Senders ref: SSI 10048 (Blacktown)

Subject: Notice of Exhibition – Sydney International Speedway (SSI 10048)

EES have reviewed the Biodiversity Development Assessment Report (BDAR) prepared by Jacobs dated July 2020, and:

Figure 2-1 Location of plot based floristic vegetation survey and vegetation integrity assessments

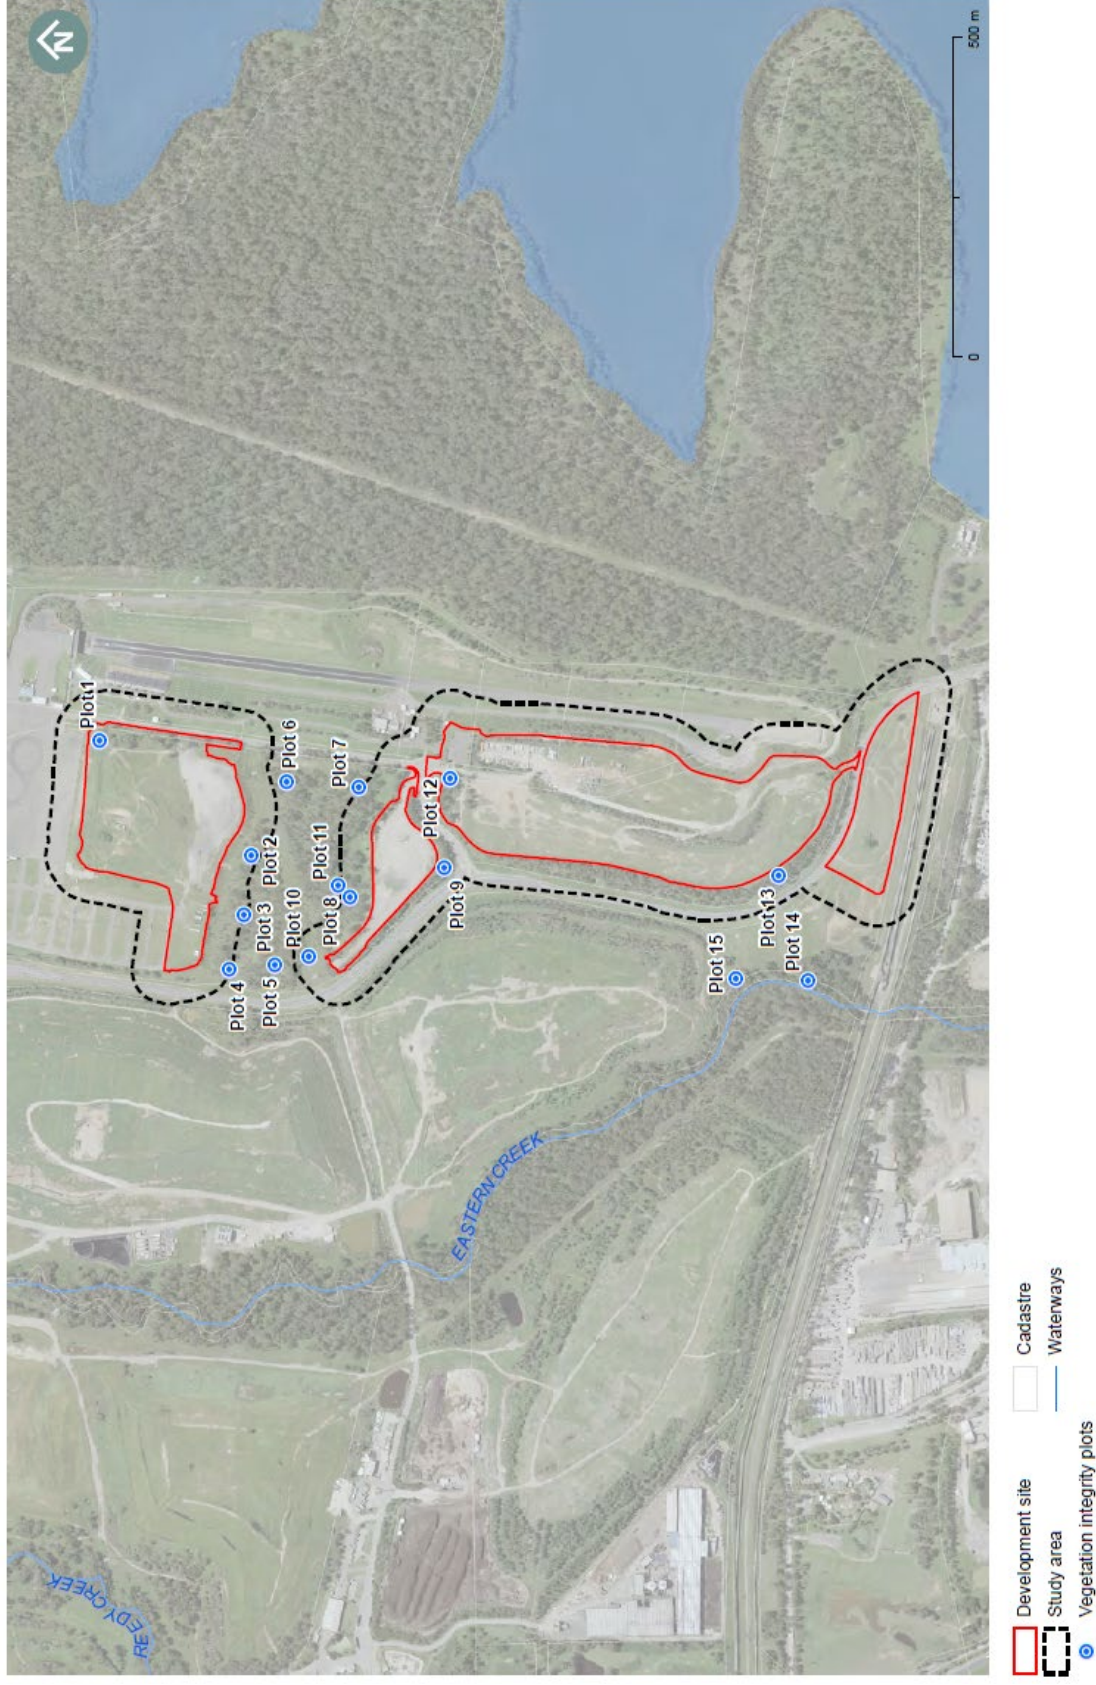
- there is no map provided of plot locations relative to PCTs, and also, it is preferable that plot locations are shown as rectangles not circles
- Table 5-1 lists a number of species that it says have been excluded from the assessment, but they are not excluded in the BAM-C: Speckled Warbler Spotted Harrier, Brown Treecreeper, Painted Honeyeater, White-bellied Sea Eagle, Hooded Robin, Black-chinned Honeyeater, Turquoise Parrot, Yellow-bellied Glider, Scarlet Robin, Flame Robin, Koala, Diamond Firetail, *Dillwynia tenuifolia* population at Kemps Creek

Figure 4-1 Plant community types and vegetation zones

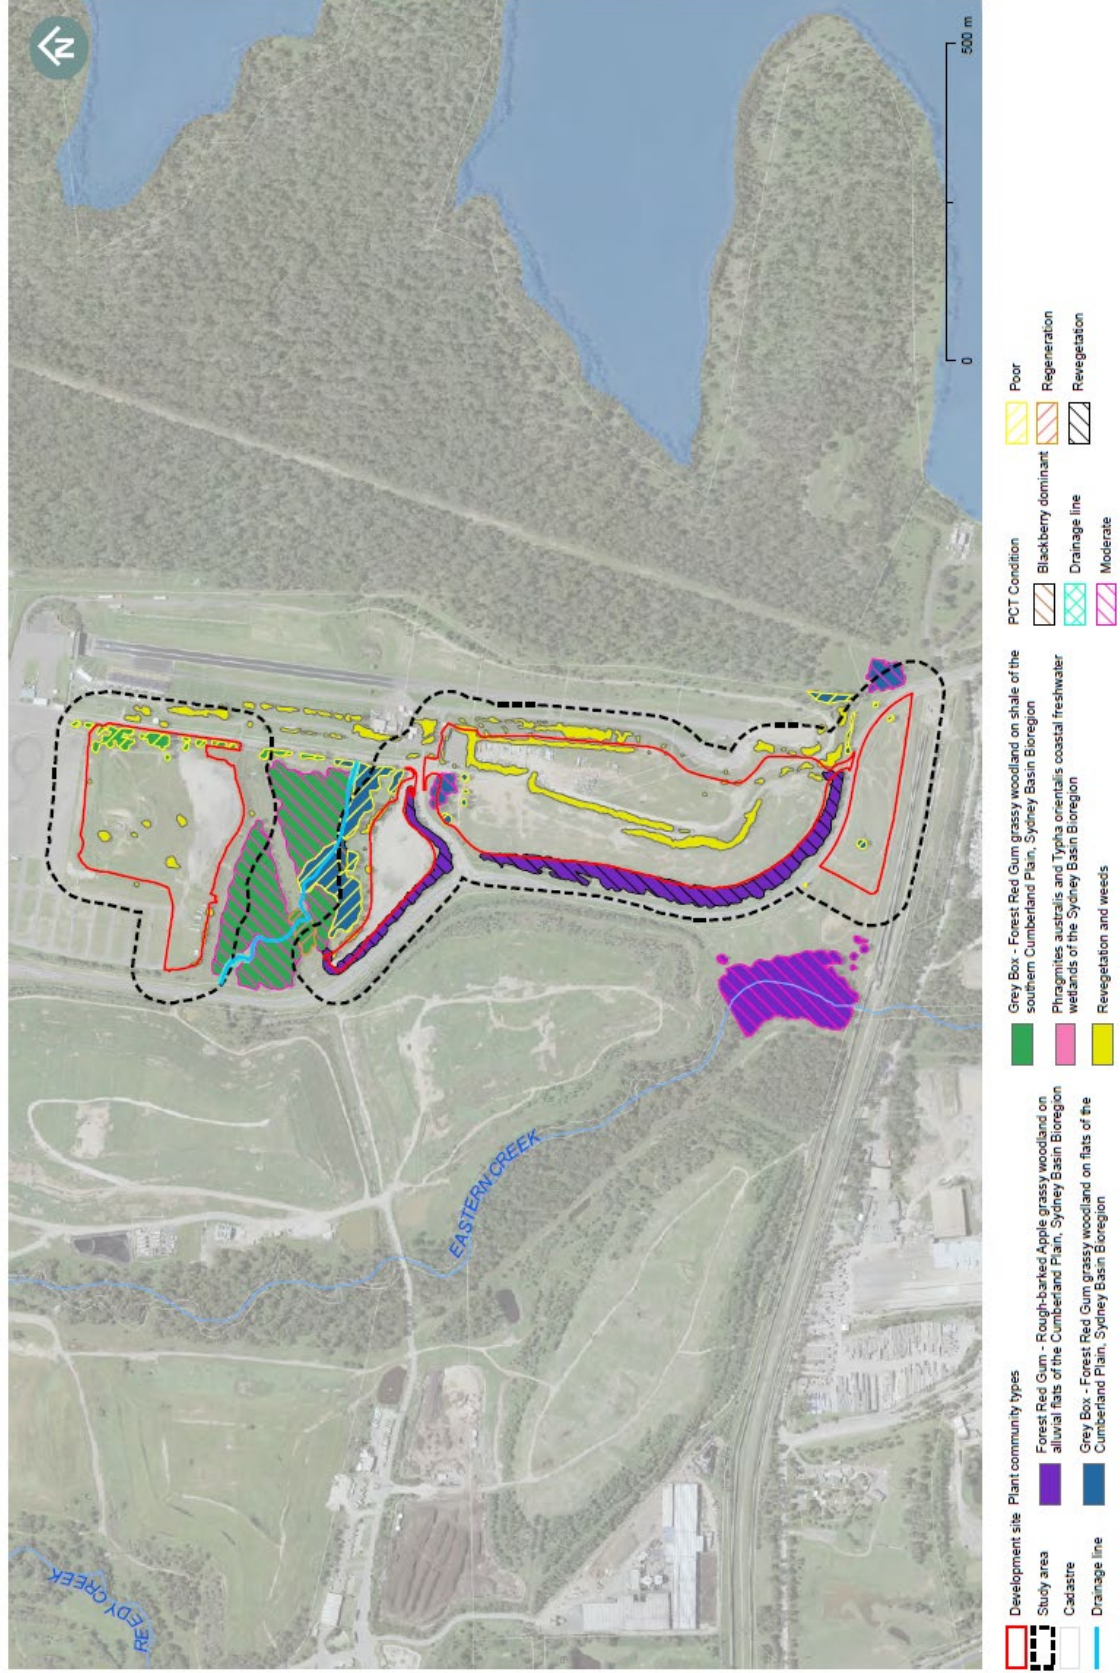
- the BDAR does not include a finalised credit report
- the BDAR states that spatial data was supplied but it has not been received by EES
- the BDAR does not contain a discussion of previous vegetation mapping of the site, and the description of the vegetation zones in section 4.1.1 is not consistent with the descriptions in Table 4-1

Figure 5-1 Threatened species polygon for Southern Myotis (Myotis macropus)

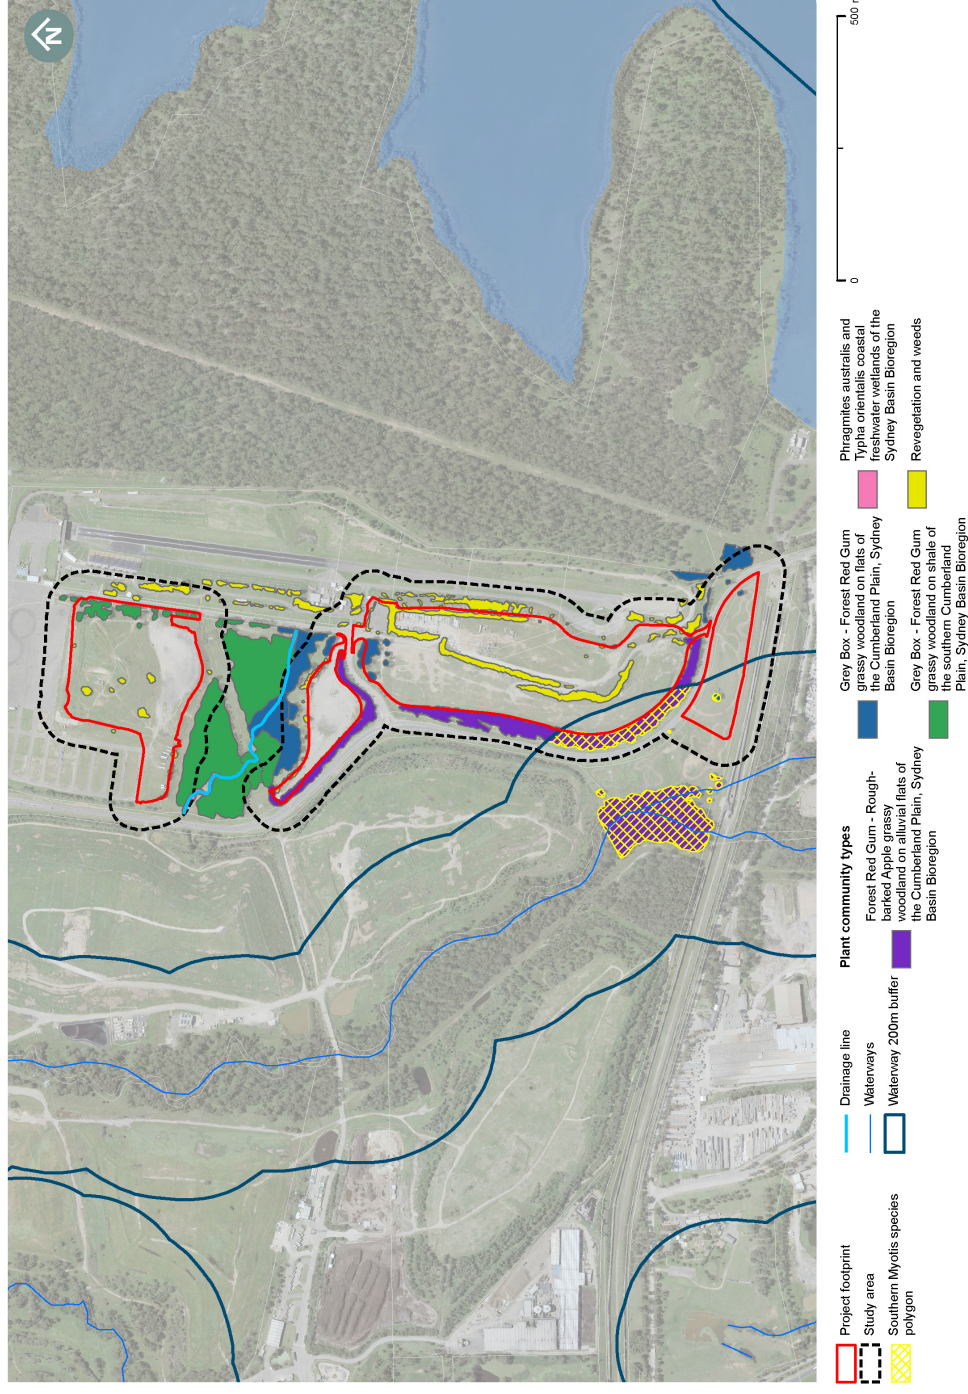
- the BDAR incorrectly states that zero credits are required for the Southern Myotis. The number of credits required is one. While it is acknowledged that the BAM-C has incorrectly calculated that zero credits are required, the BDAR should have noted this error and stated that one credit is required, in accordance with s 11.2.4.5 of the BAM, and the guidance in the Operational Manual in relation to proposals where the total number of credits is less than one, and
